Subject: Further DOCC comments for application 2025/93543 at land at former Clough Mill, Clough Road, Slaithwaite, Huddersfield, HD7 5DB

Re: 2025/93543- REVISED AND ADDITIONAL INFORMATION RECEIVED, AND REVISED DESCRIPTION: Erection of 31 dwellings (c3) with access from Clough Road and associated works including engineering operations, construction of retaining walls and landscaping at land at former Clough Mill, Clough Road, Slaithwaite, Huddersfield, HD7 5DB

2517-HT-AP-01 - APARTMENT FLOOR PLANS
CLOUGH ROAD, SLAITHWAITE
SB HOMES
SCALE:1:200@A3 - DECEMBER 2025

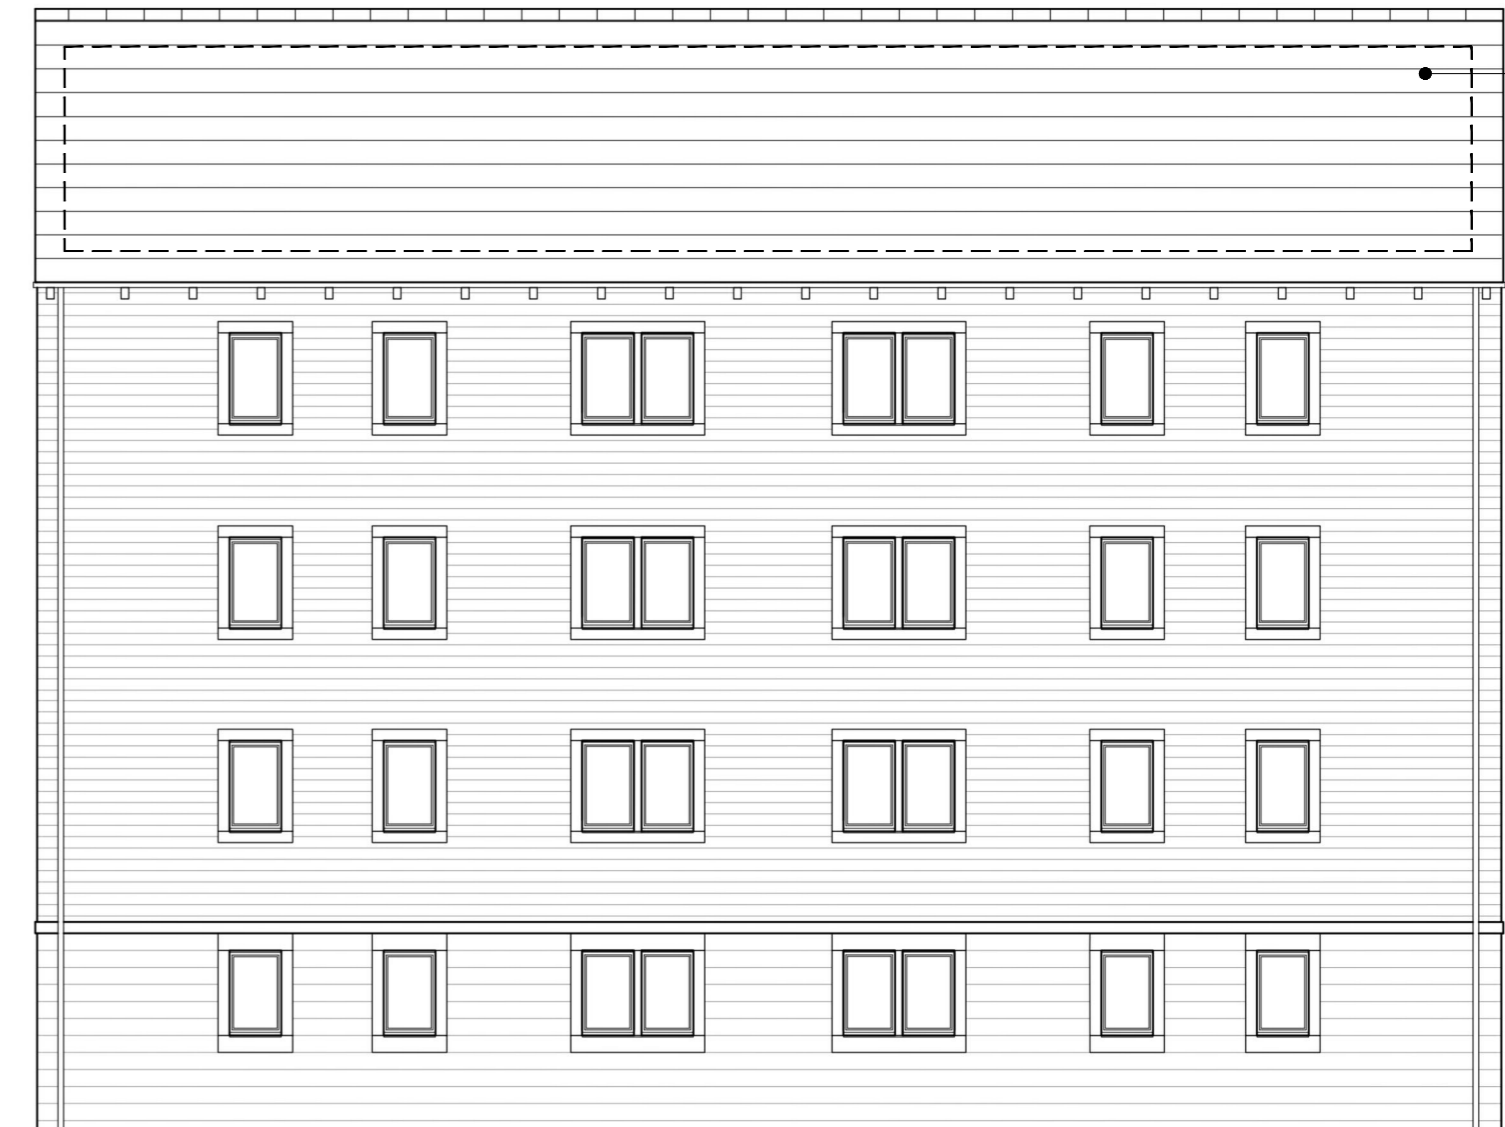
The steps to amenity space in the apartment block appear to allow unrestricted access to the first floor of the building (particularly semi-open amenity space and plot 23's door)- this is discouraged; access and movement throughout the building should be controlled to mitigate opportunities for acquisitive crime and antisocial behaviour.
